From: Thomas Callaway
Sent: 22 June 2015 14:48
To: Planning.Responses
Subject: RE: Planning Consultation on AL/46/15/DOC

APPLICATION NO: AL/46/15/DOC

Site Address: Land adjoining Sunnyside Westergate Street Westergate PO20 3QR

Description of Works: Application for approval of matters reserved by condition imposed under AL/114/12/ relating to conditions 3,4,5,7,9,12,13,15 & 16 for schedule of materials & finishes & samples, site set up during construction, public right of way, surface works for right of way, landscaping scheme, surface water drainage, SUDS system, translocation of reptile population & design of access road.

Revision		Amendment		Approved		Revision Date		Project			
								R/O "Sunnyside", Westergate.			
								Sheet			
								Drainage			
P2	GENERAL AMENDMENTS.			APT		22.04.2015					
P1	FIRST ISSUE			-		27.03.2015

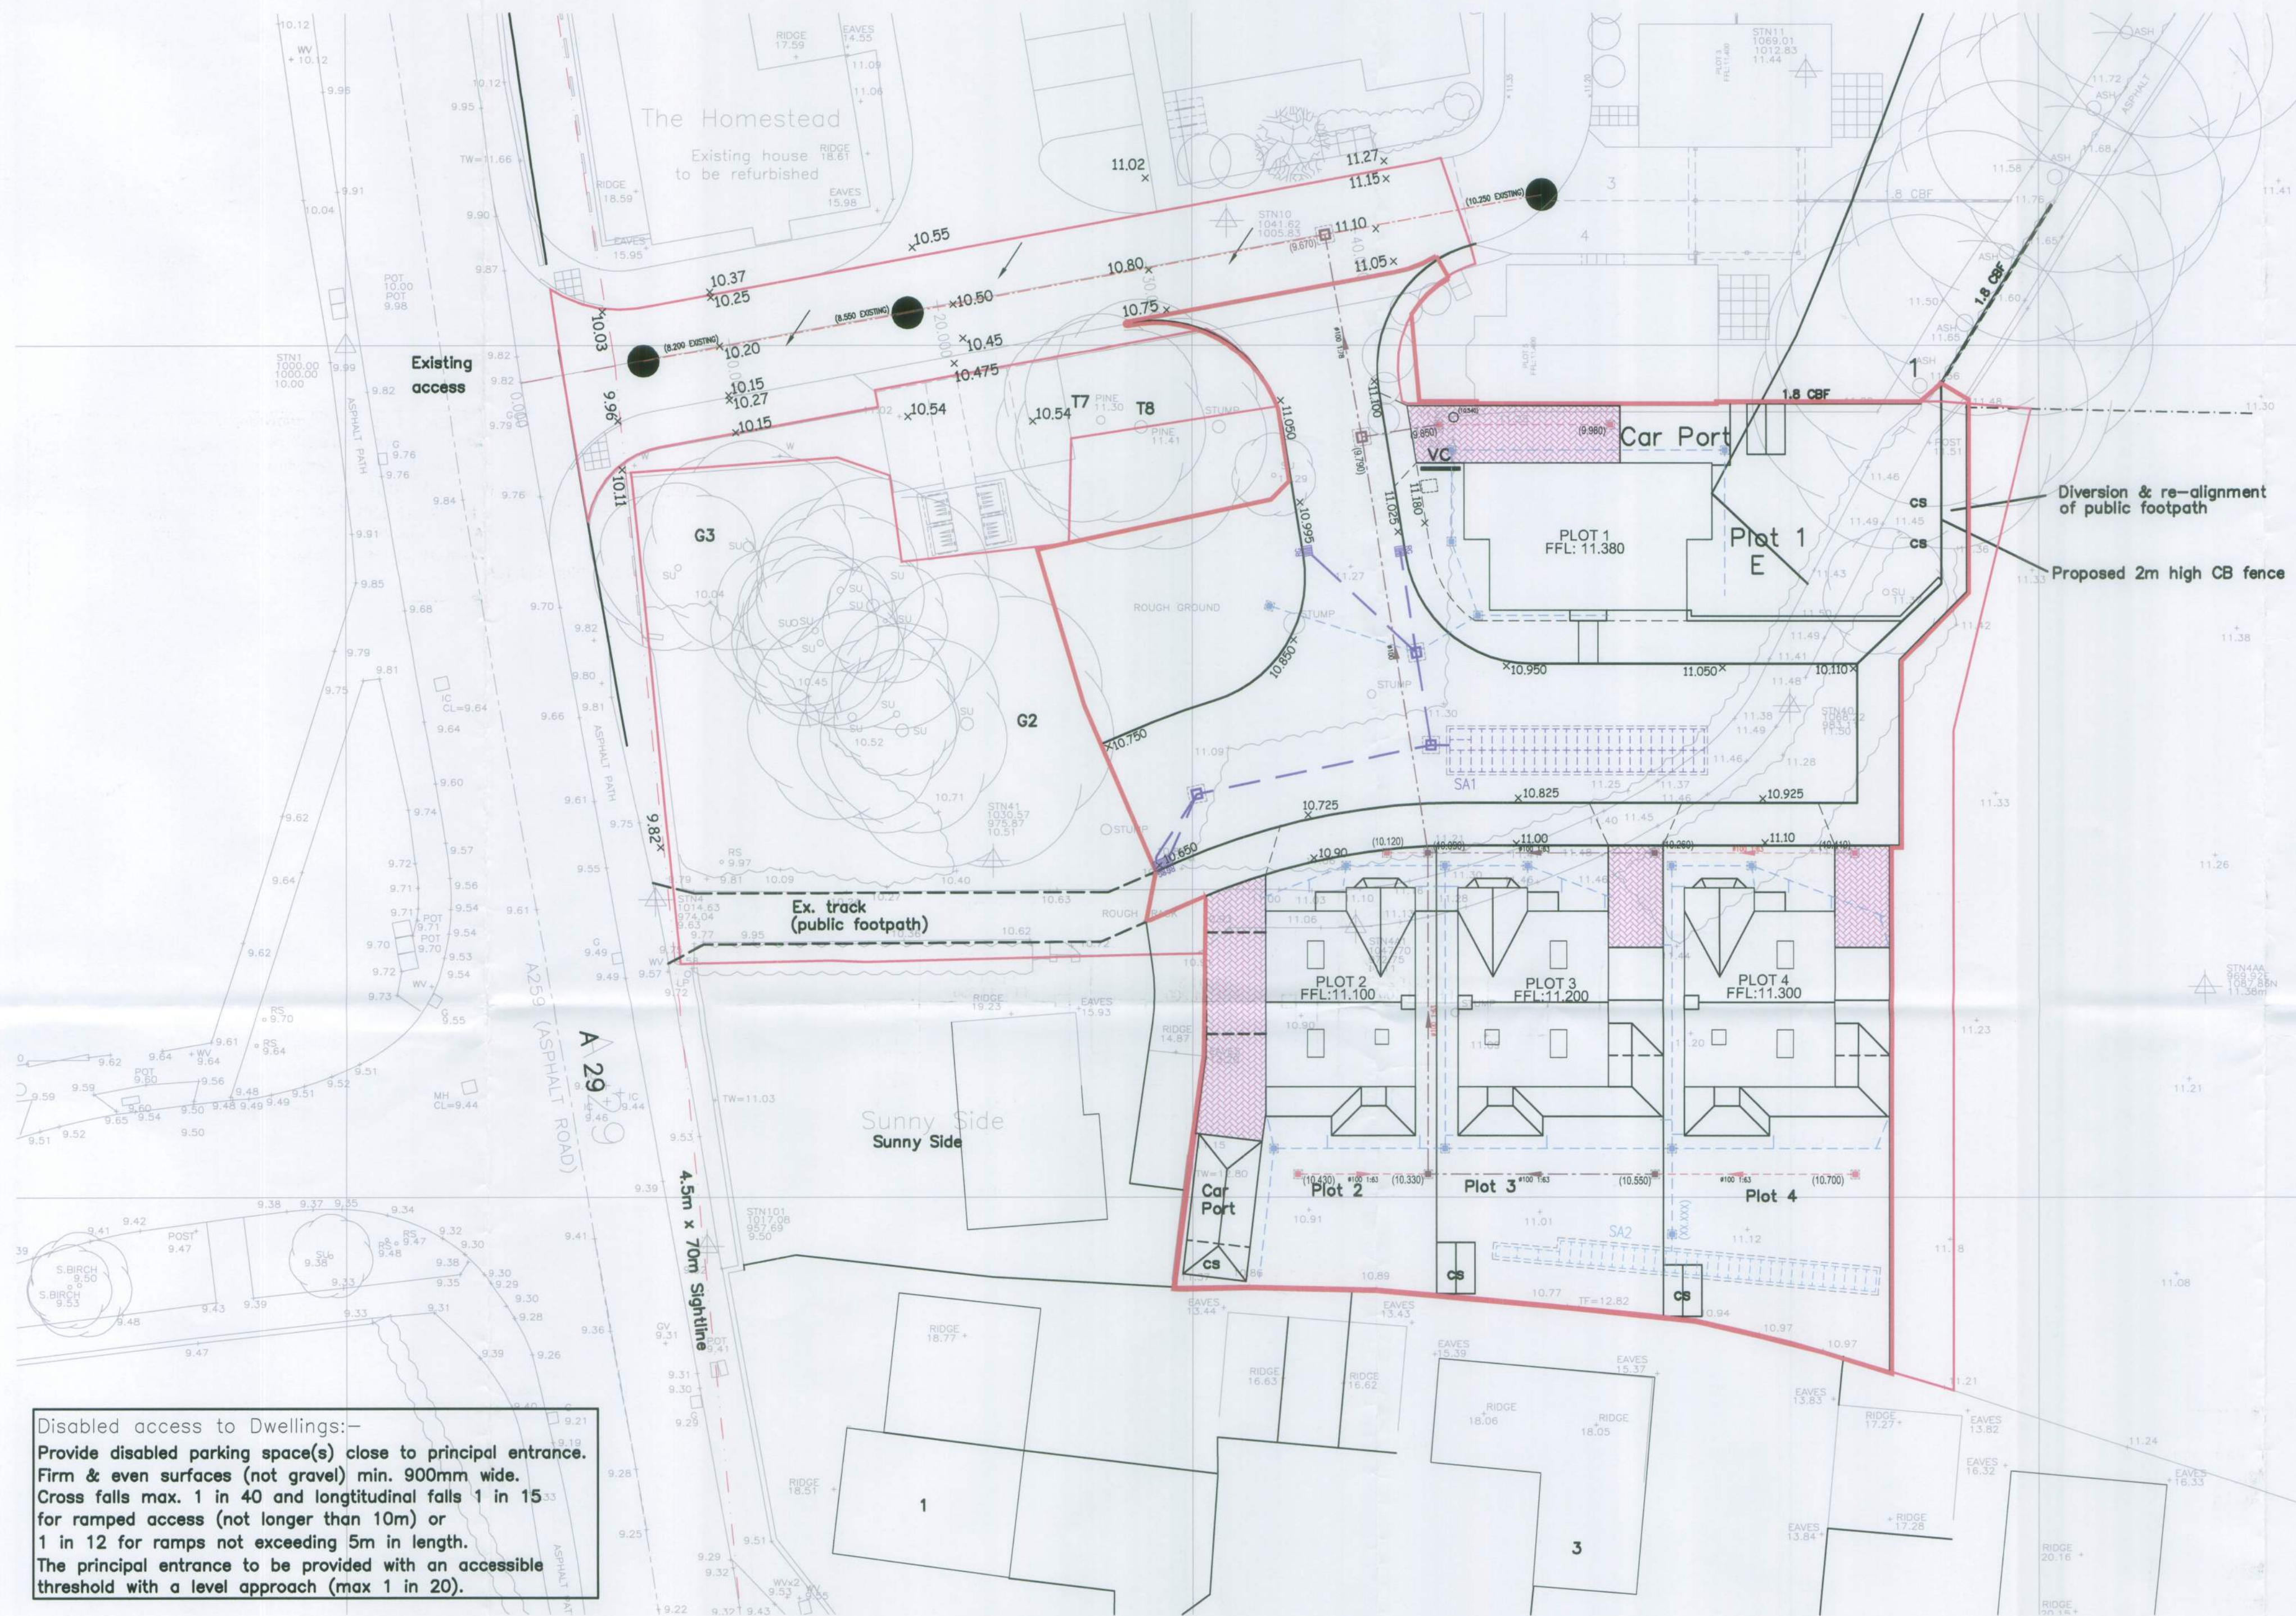
Could we please also have specific construction details including capacity and levels for the soakaways. Calculations should be provided to confirm that the 1 in 100 year storm event plus 30% is stored in the soakaways/paving for all impermeable areas without causing flooding. The base levels of soakaways should be above the highest recorded groundwater level.
